# CITY OF ALBUQUERQUE

August 15, 2012

**Re: Atrisco Apartments, 1720 Atrisco Drive NW,  
Grading and Drainage Plan  
Engineer's Stamp Date 6/28/2012 (H11/D068)**

Based upon the information provided in your submittal received 07-11-2012, the above referenced plan can not be approved for Building Permit and SO-19 Permit until the following comments have been addressed:

sheet no: 01.0
RECEIVED
1042012
LAND DEVELOPMENT SECTION

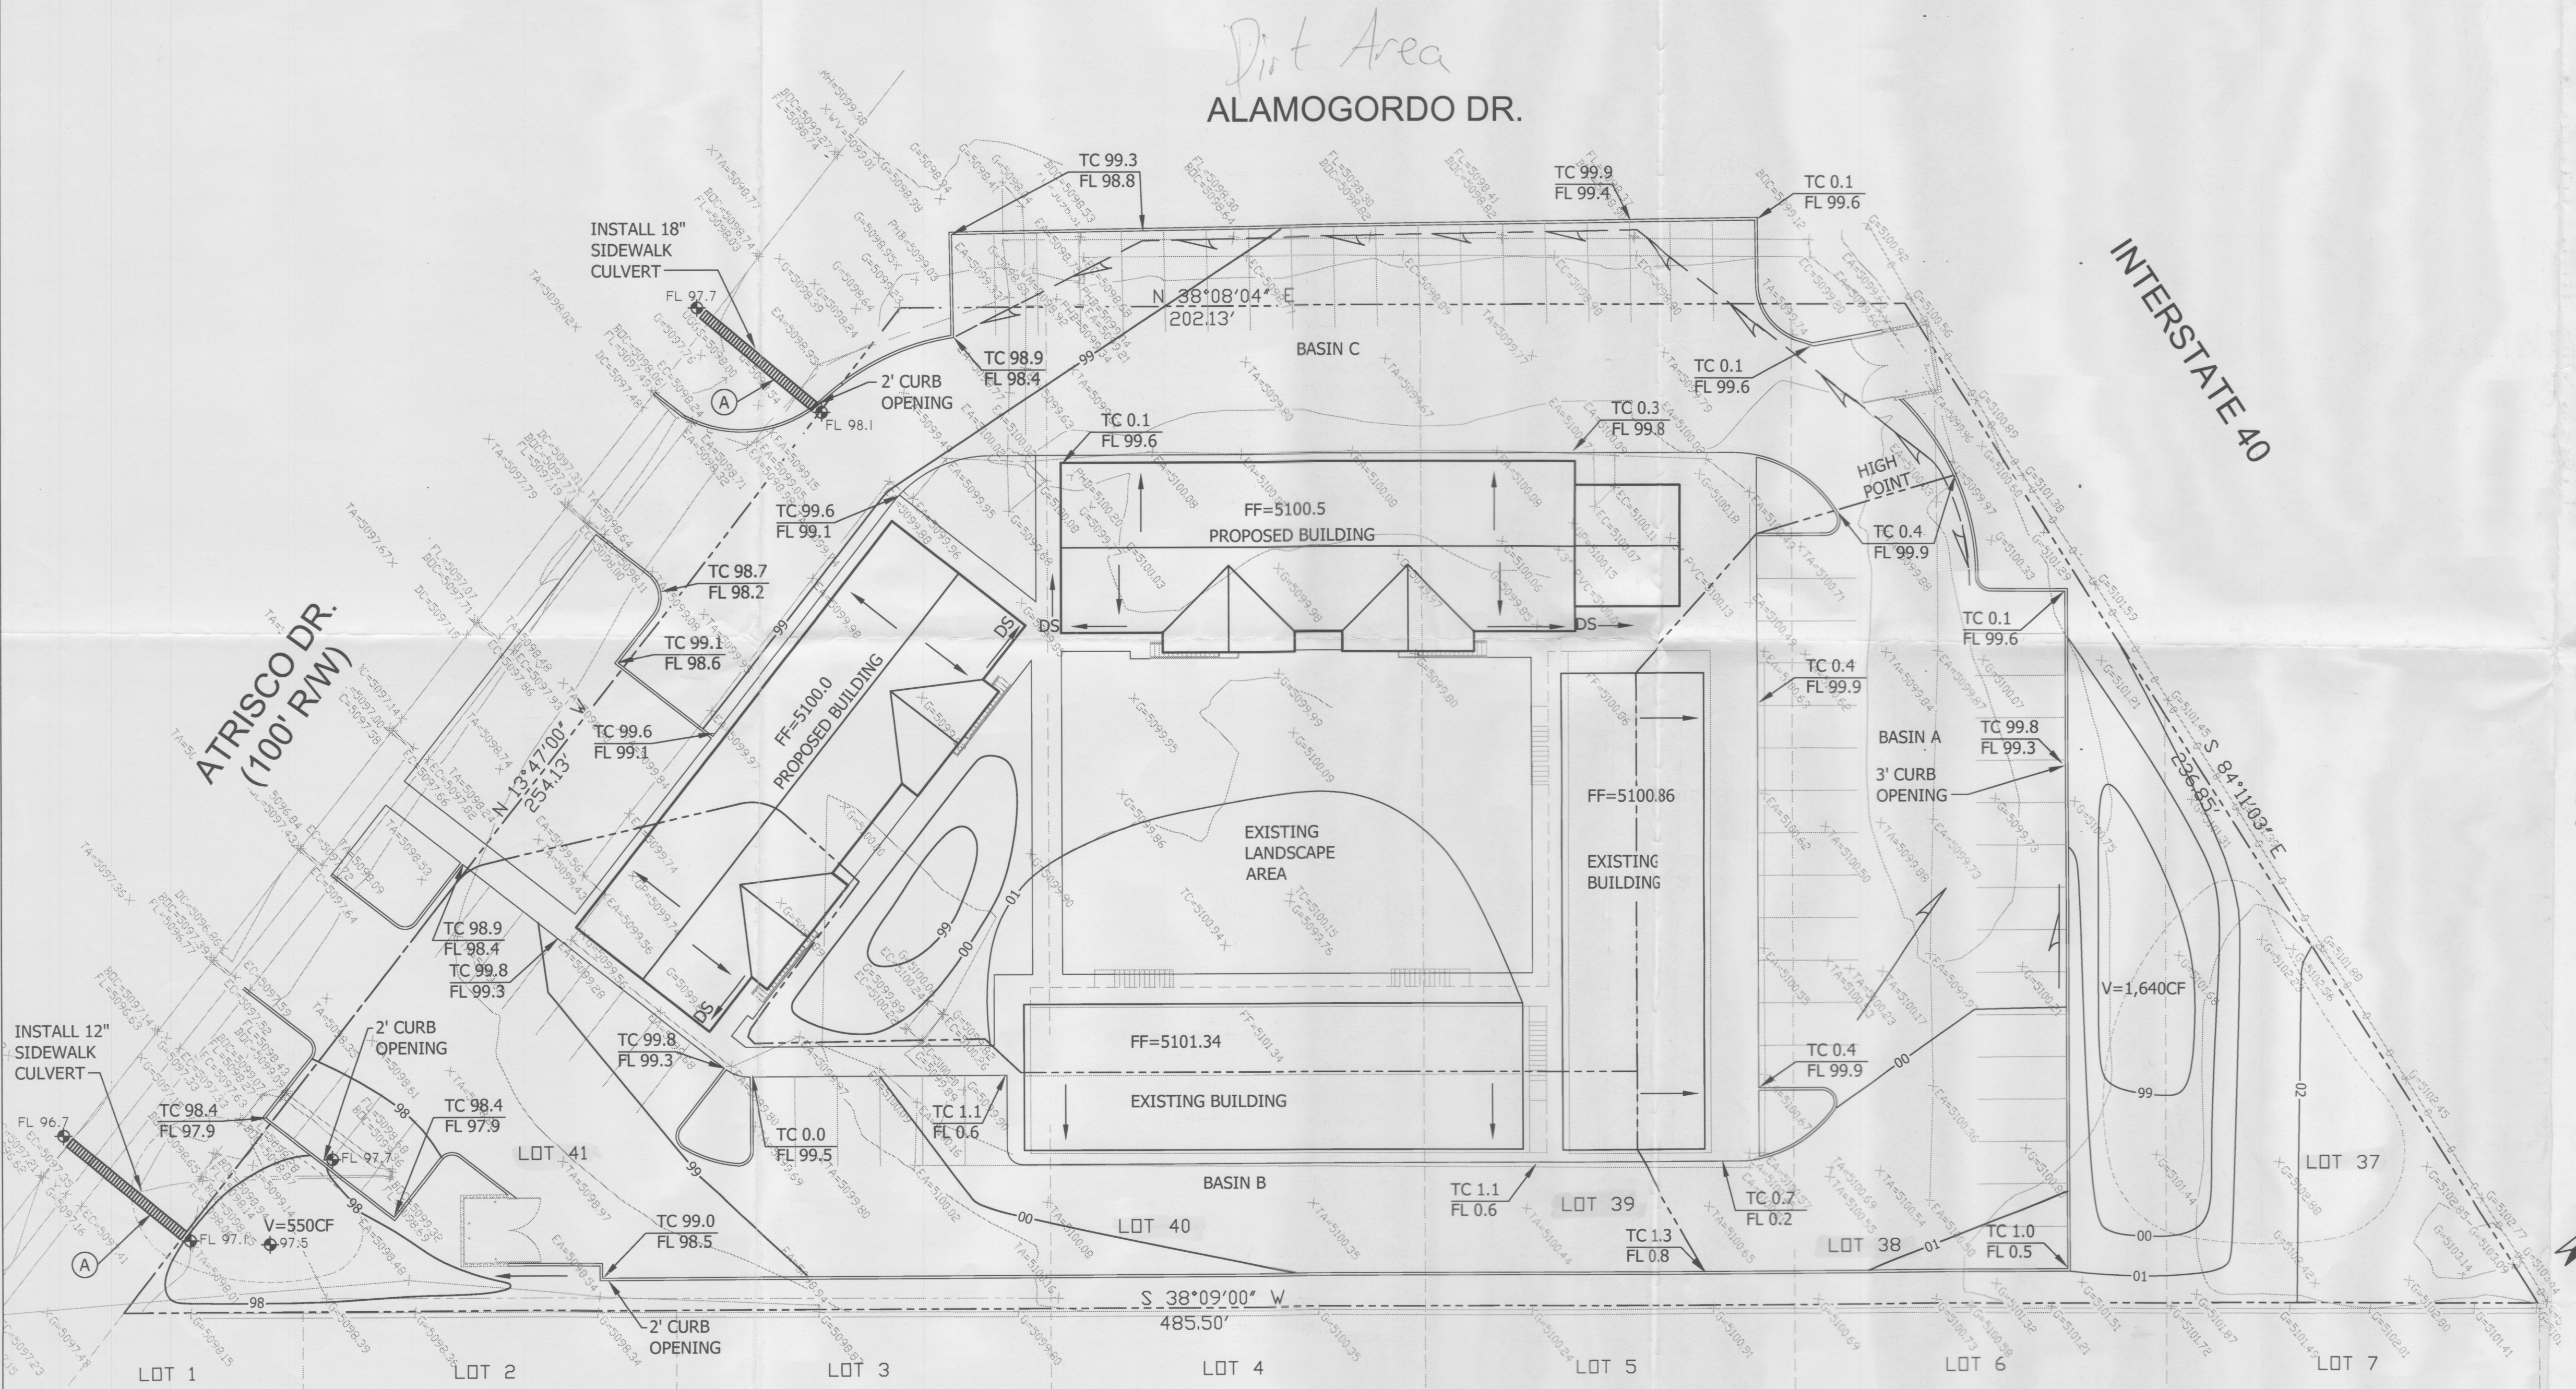
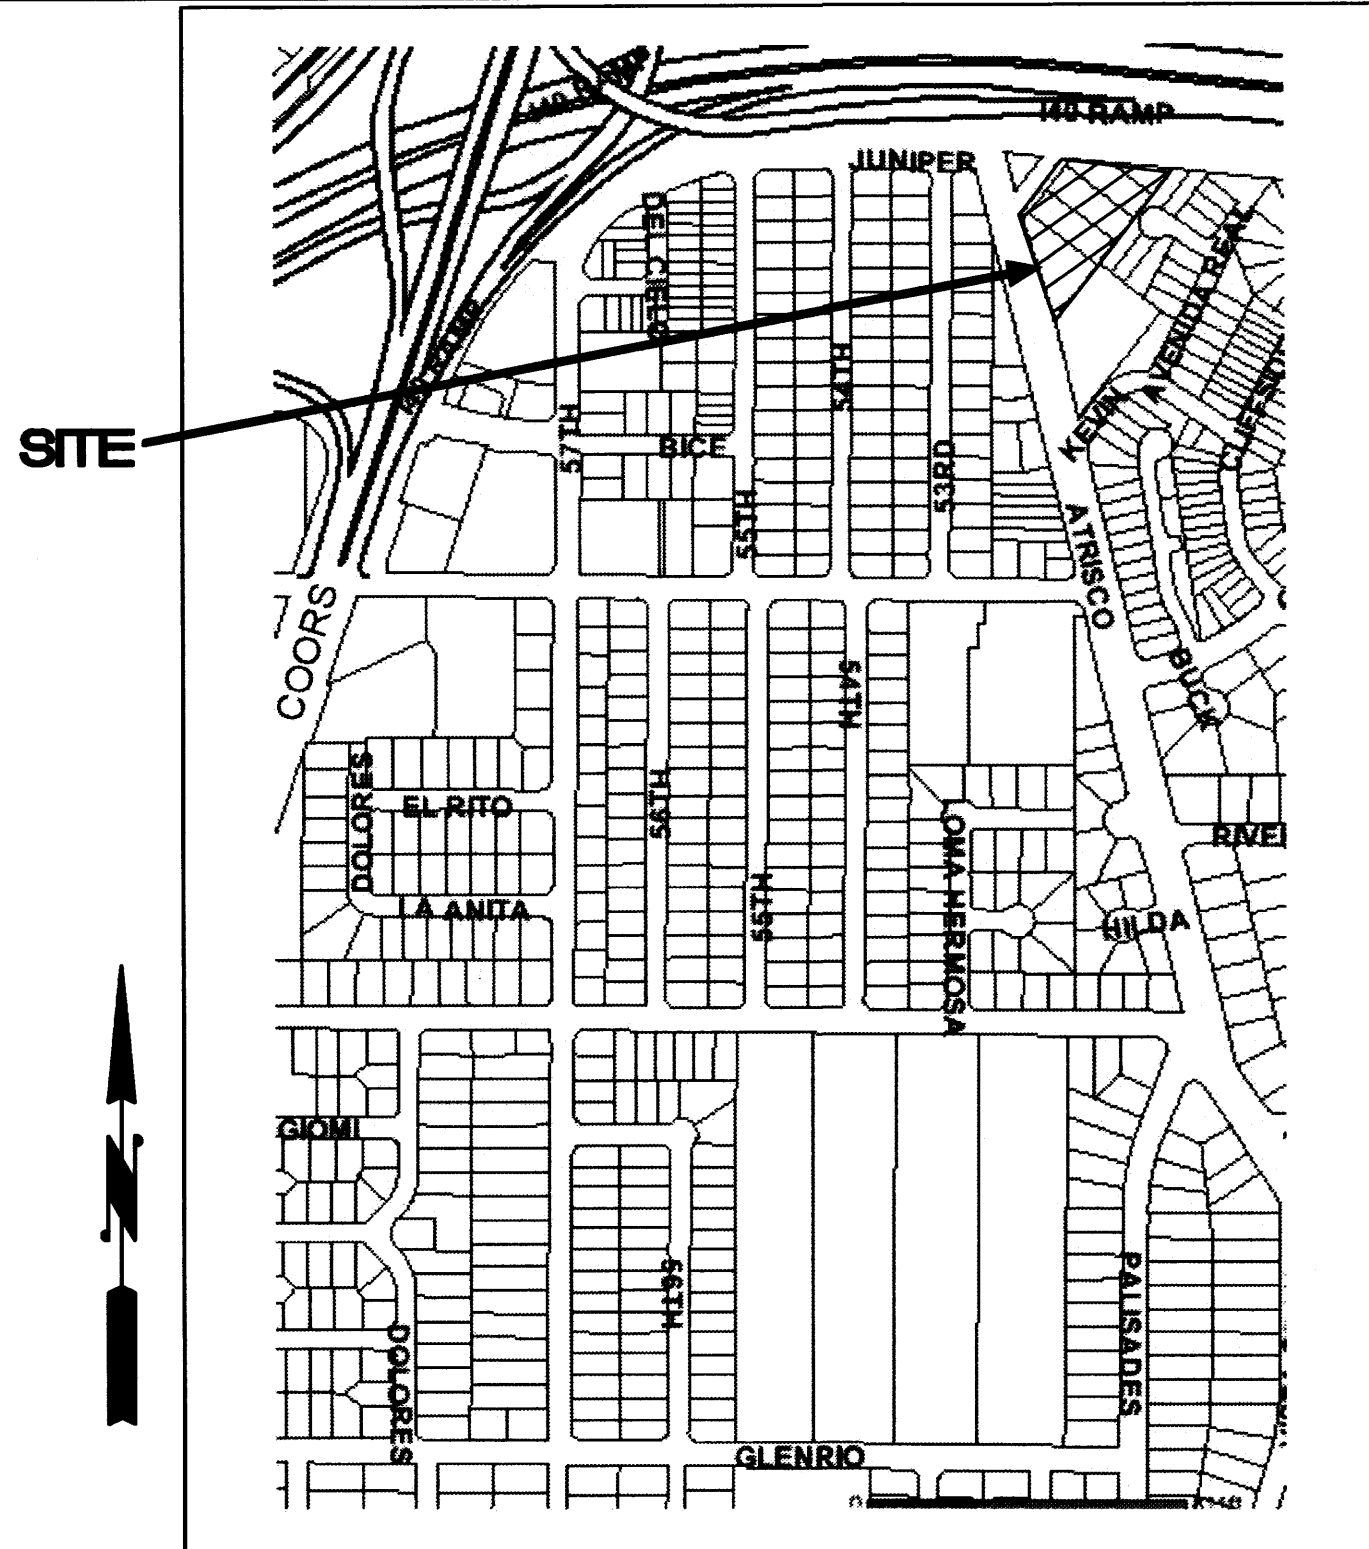
- Show the amount runoff draining to the northerly pond.
- Provide pond volume calculations for all the ponds.
- Clearly show the high point on site. Some of the flow arrows directions may have to be changed.
- Depressed all landscaping areas where possible.
- Provide sidewalk culvert capacity calculations.
- Is the curb and gutter along Atrisco Dr. exiting? Please show the full extends of the curb and gutter.
- Extend the easterly sidewalk culvert to the face of the curb.
- Call out the City of Albuquerque Standard Drawing number for the sidewalk culvert. Also include a note that the bolts be tack welded at the plates.
- Encroachment Agreement with City of Albuquerque will be required for the westerly parking area outside of the property line. Please contact Jane Rael at 924-3992 in regards to the Encroachment Agreement.
